HUNTER THOROUGHBRED BREEDERS ASSOCIATION – SUBMISSION ON MT ARTHUR MODIFICATION

The Hunter Thoroughbred Breeders Association (HTBA) appreciates the opportunity to comment on the BHP Billiton's Environmental Assessment (EA) for Mt Arthur Modification.

Figure 21 Predicted Final Void Water Levels

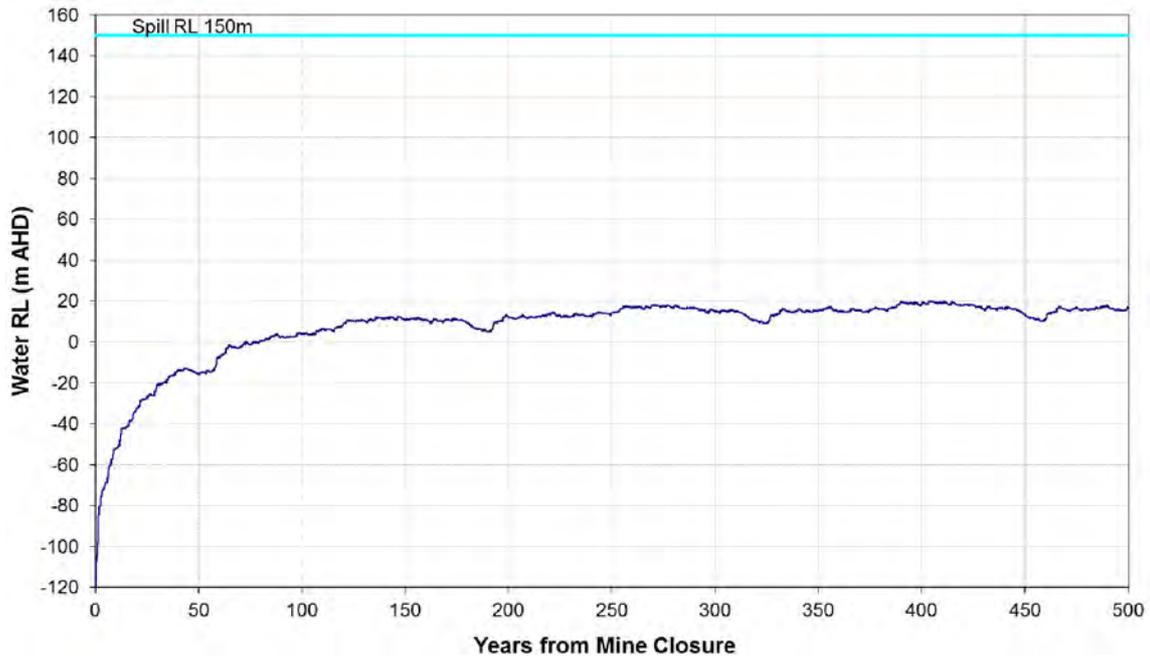
- no discussion of the impact of the void on the long-term suitability of water for downstream users and the environment;
- significant and unexplained differences in final void water level results between the modelling completed by groundwater consultants (between RL 45m and 59m) compared with the level referenced in modelling undertaken by surface water consultants (RL 20m). These differences
